From: Karen Garner on behalf of Planning.Responses
Sent: 05 April 2012 15:54
To: Janice James
Subject: FW: FP/40/12 - Church House, Felpham

Sent: 05 April 2012 09:00
To: Susan Leeson
Subject: FP/40/12 - Church House, Felpham

Further to the objection submission made by Felpham Parish Council via the online system for the above application, additional information has come to light.

EXISTING SECOND FLOOR PLAN
Scale 1:100

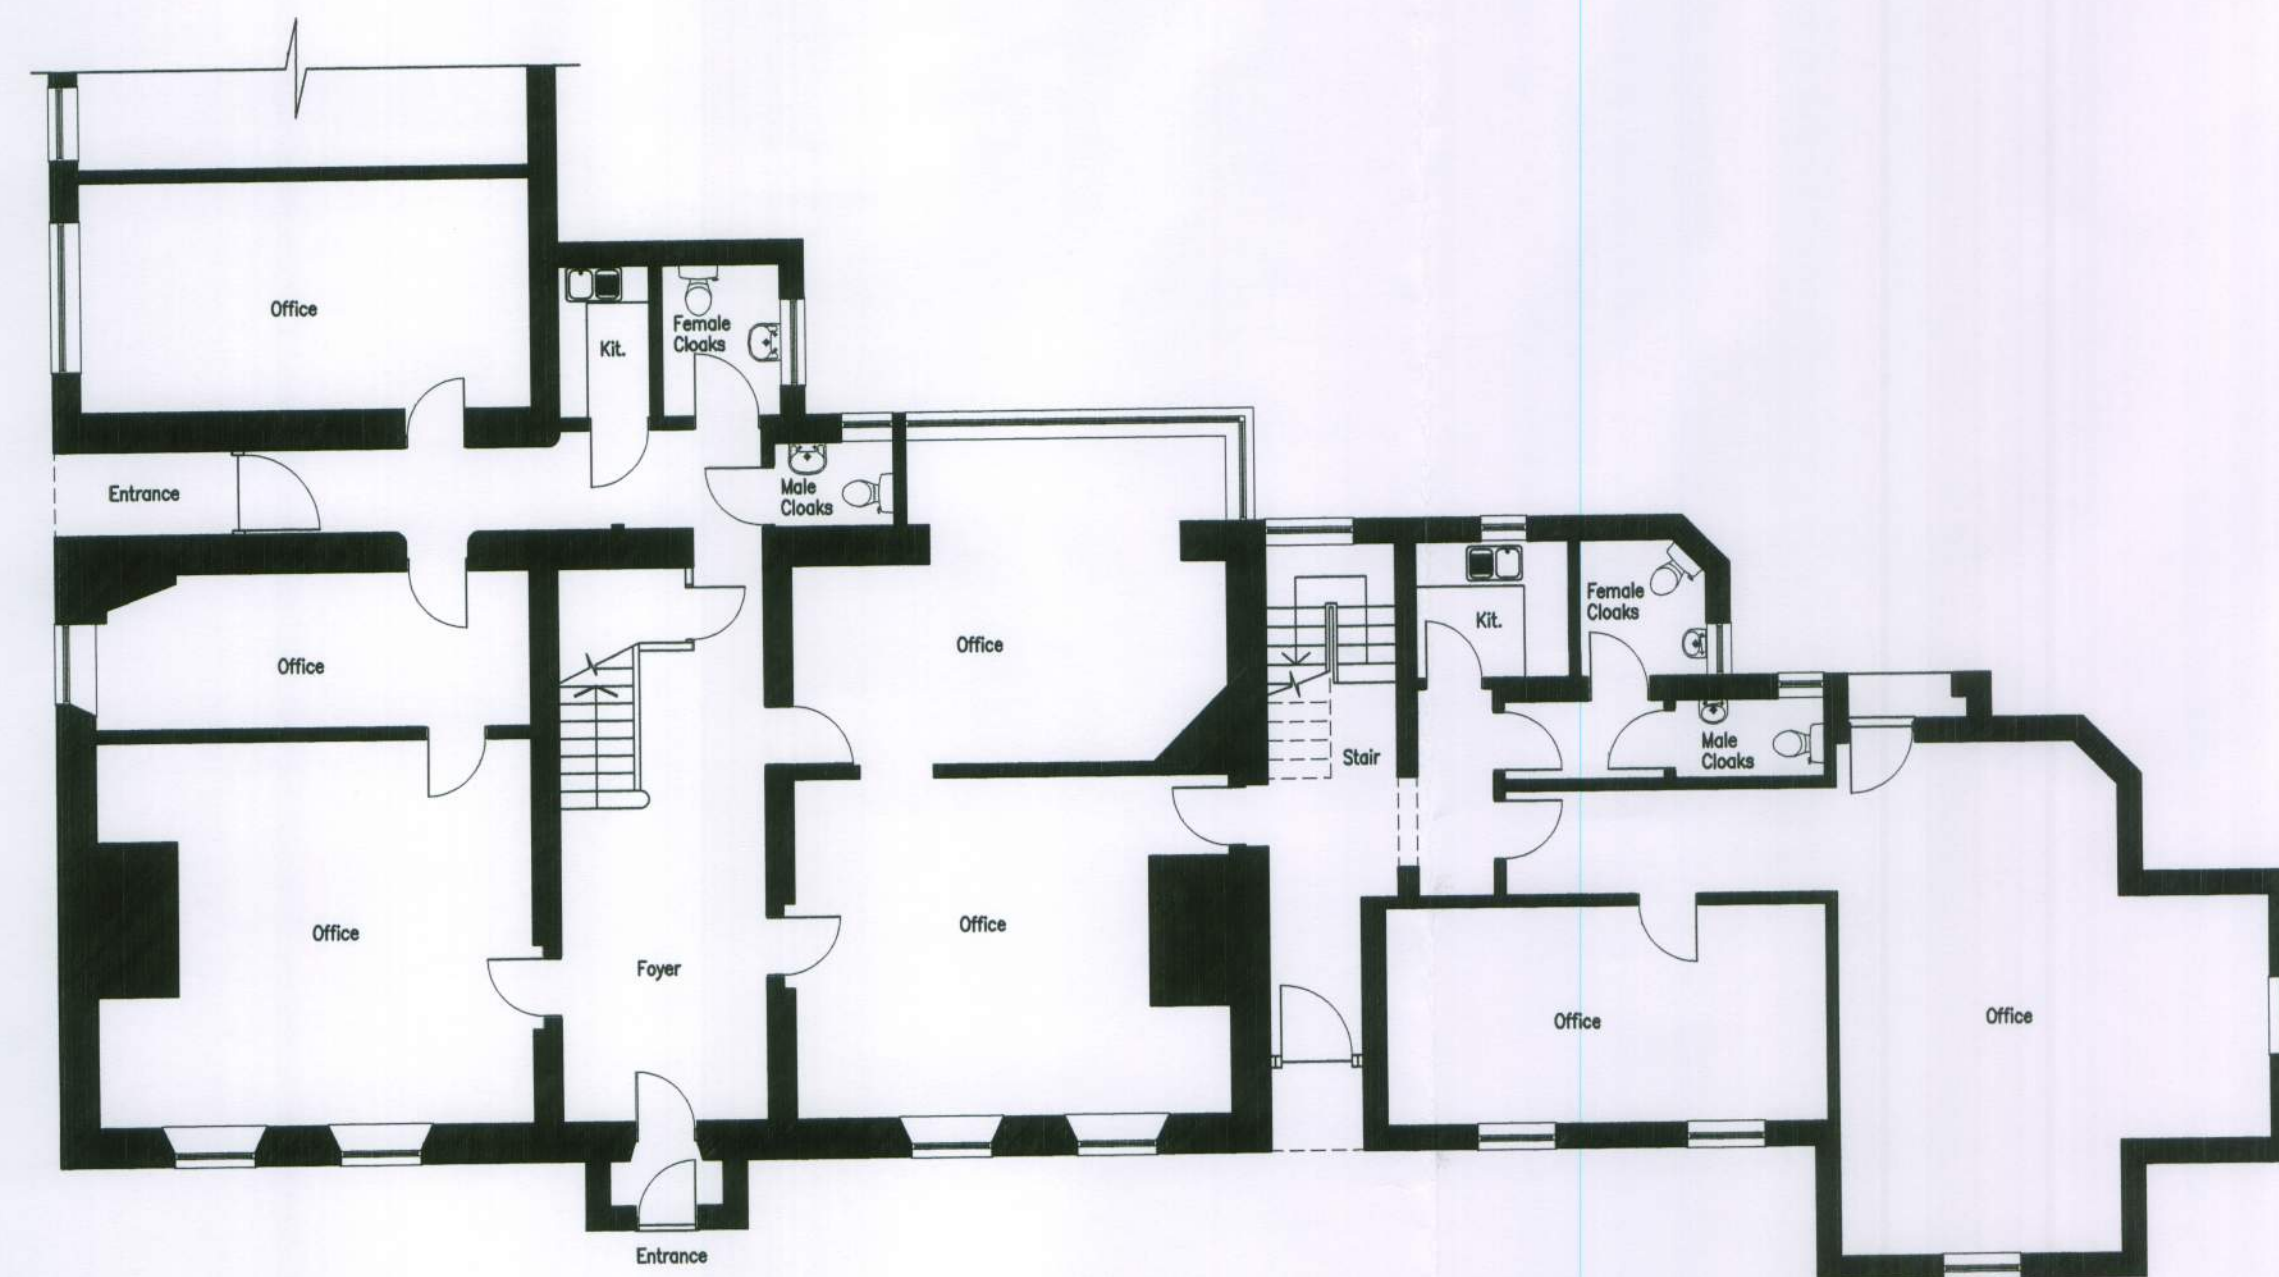
- We are concerned about increased access & egress to the site.
- We believe there are bats in the roof.
- We believe there are original features inside – fireplace, staircase & ceilings that could be lost if building converted to residential use.
